Building Details

9225 Oto Circle

*LENDER/CLIENT: Adrienne Bieger
JOB NUMBER: 191296

Site Plan_v1-redline.pdf Markup Summary

# Building Details

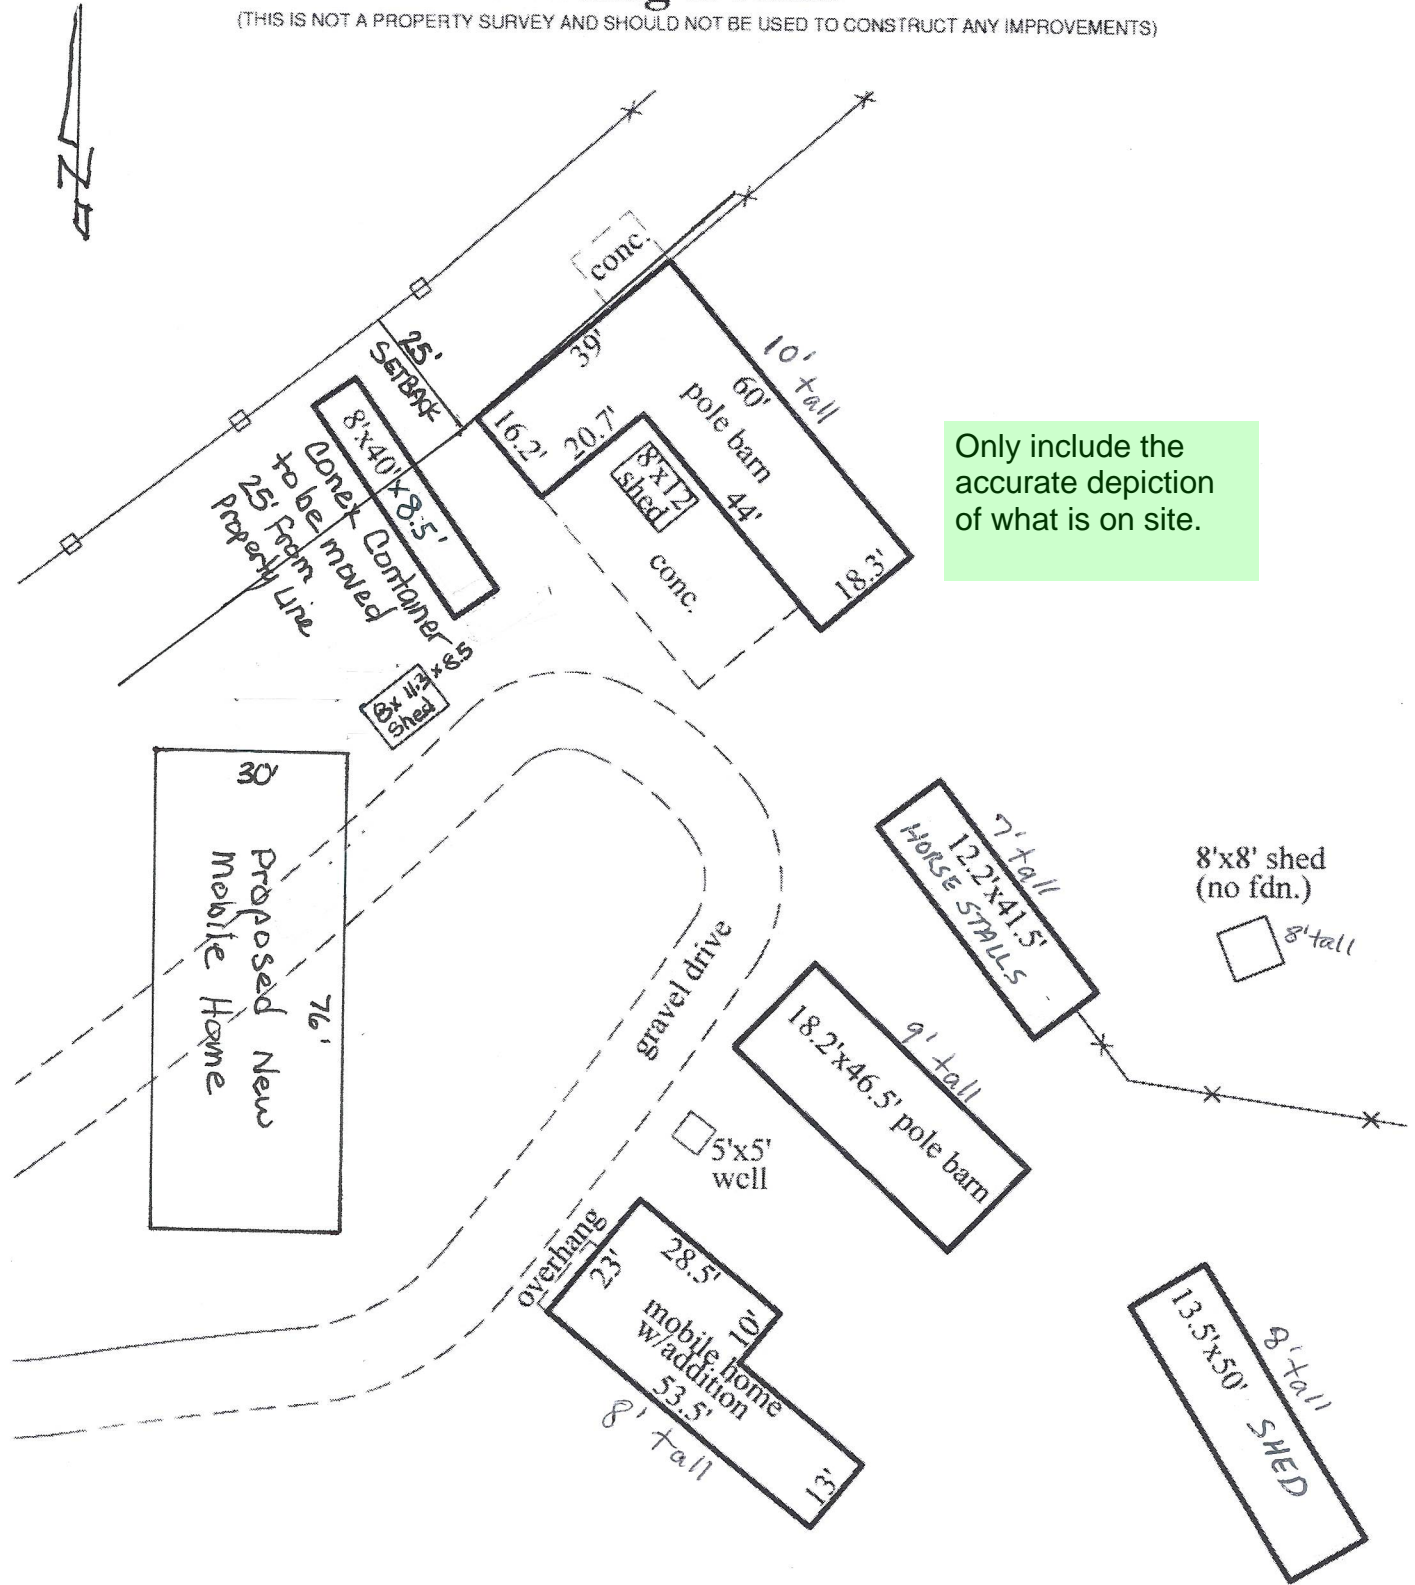
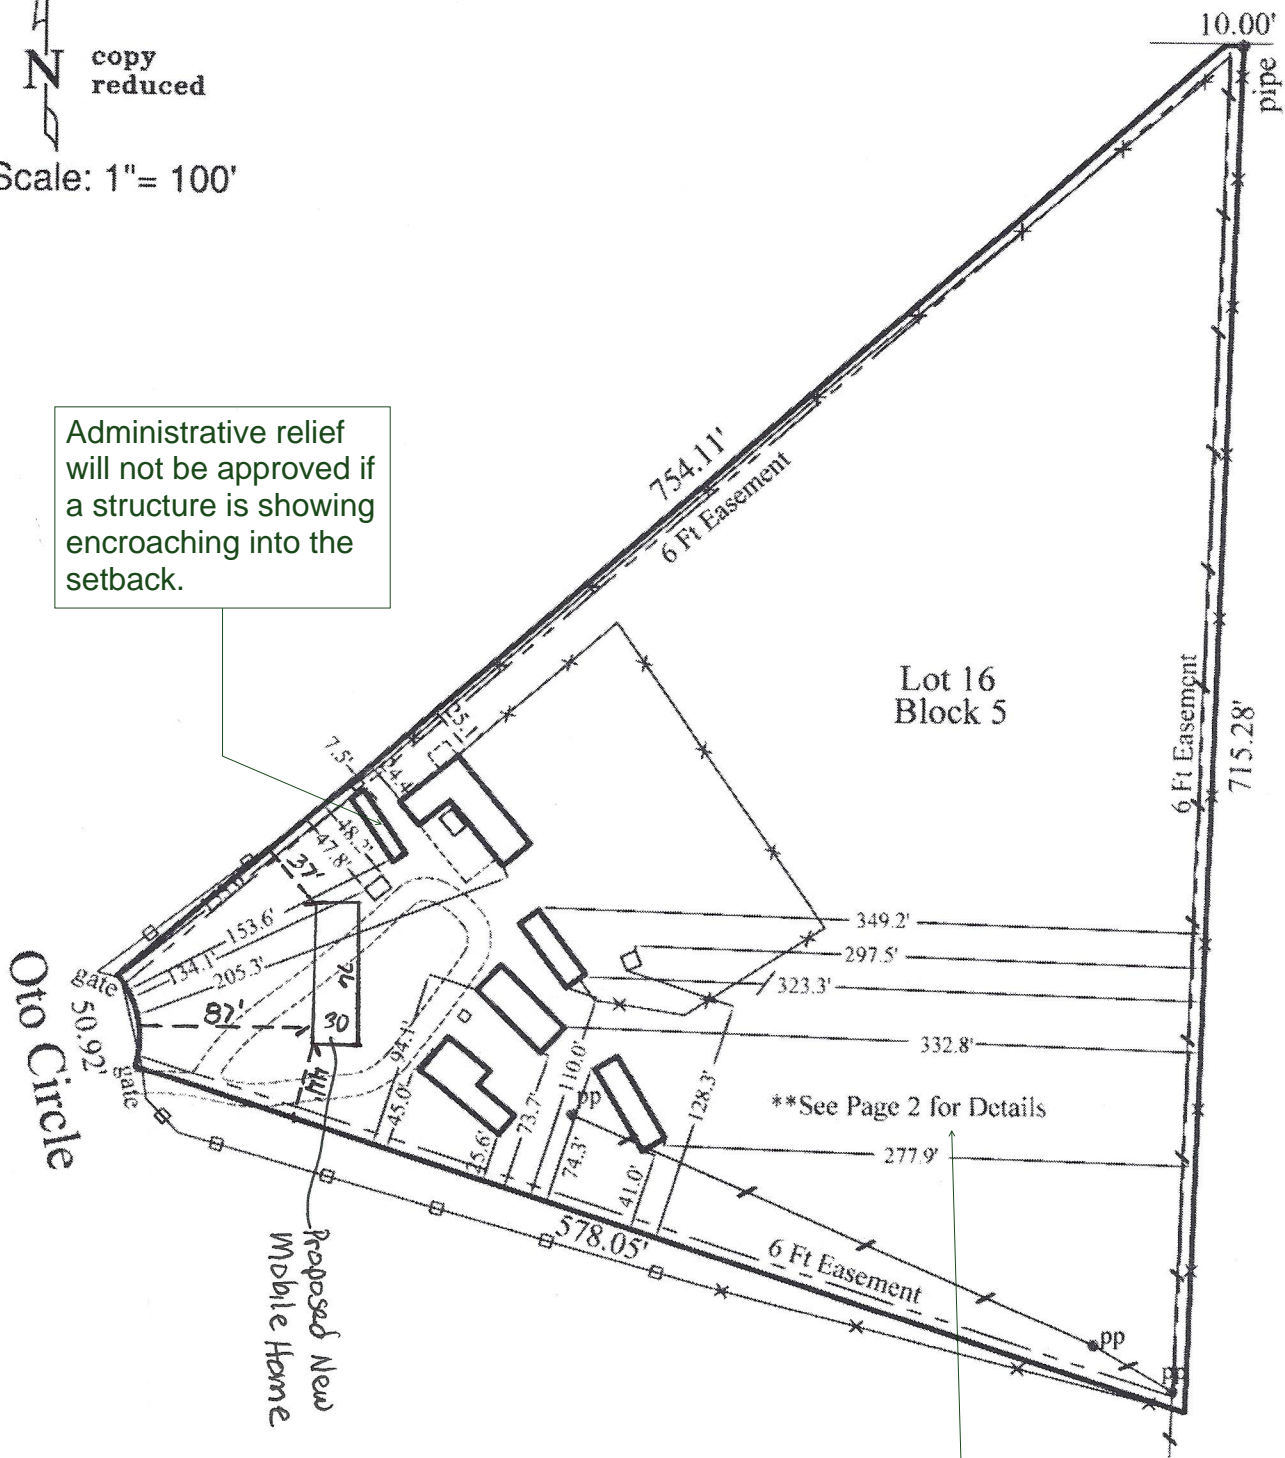
Administrative relief will not be approved if a structure is showing encroaching into the setback.

Only include the accurate depiction of what is on site.

Page 2 should be attached or this note should be eliminated.
